**Consultation Response from KC,
Highways Development Management**

2026/90823 373, Wakefield Road, Denby Dale, Huddersfield, HD8 8RP

Demolition of existing workshop and erection of larger workshop

Reference to Plan: 2556-D-20-003 – Proposed

2556 - D - 20 - 003

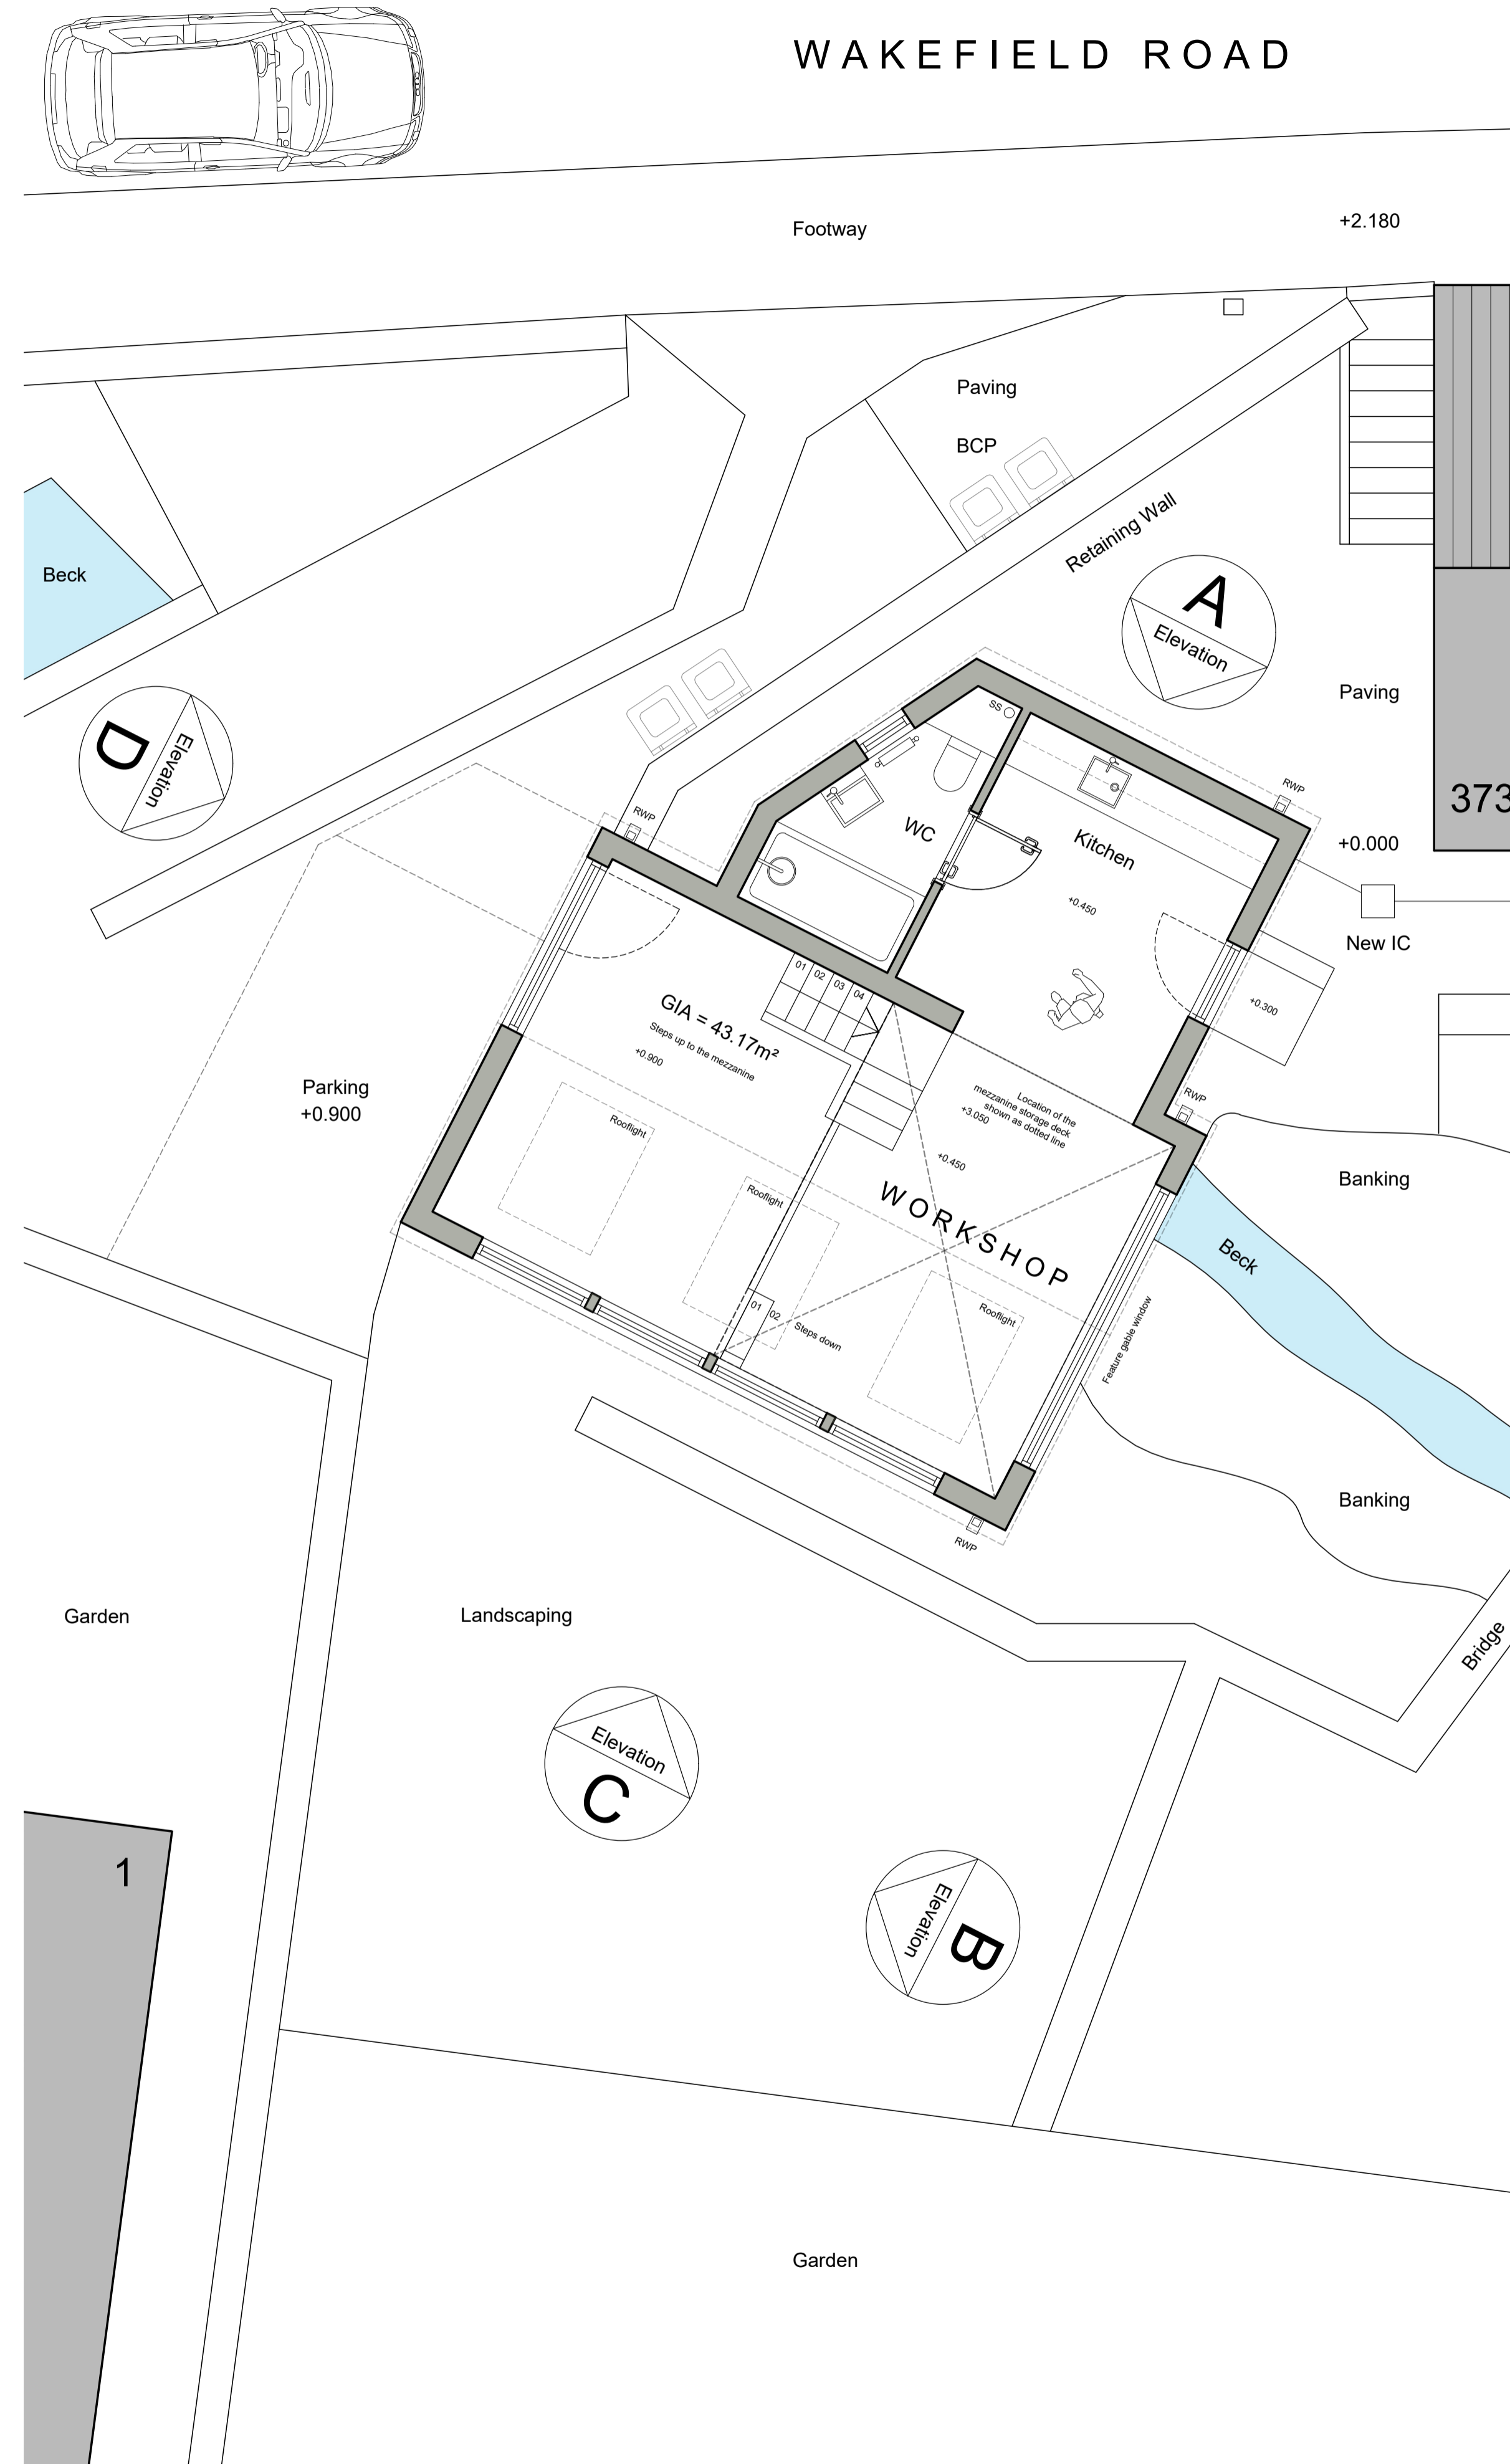
Access and parking are to be retained from the unadopted lane at north-west that connects from Wakefield Road and over which PROW Footpath DEN/68/10 passes. The increase in floorspace is unlikely to require additional parking space given a high proportion of the extension includes bathroom and kitchen space to resemble a live work unit rather than a workshop.

It is not expected that the retaining wall would be impacted negatively. Also, noted is the beck at south-east that may require the extension to have greater structural support and flood resilience and that the Environment Agency has raised an objection and requested more information.

The proposal does not raise significant issues for access, road safety, or network functionality to meet policy LP21. Should construction arise, the Footpath should not be obstructed during building works, but there may be need to temporarily close or divert it on grounds of public safety, the Applicant should contact the PROW team for more information.

The development abuts a Public Right of Way, Footpath DEN/68/10. The Applicant is advised that before undertaking any work you must contact the PROW team to discuss requirements, including the need for any Temporary Traffic Regulation Order to close or divert the PROW for the duration, or part, of the works on grounds of public safety. For more information contact highways.ross@kirklees.gov.uk or 01484 221000 and ask for public rights of way.
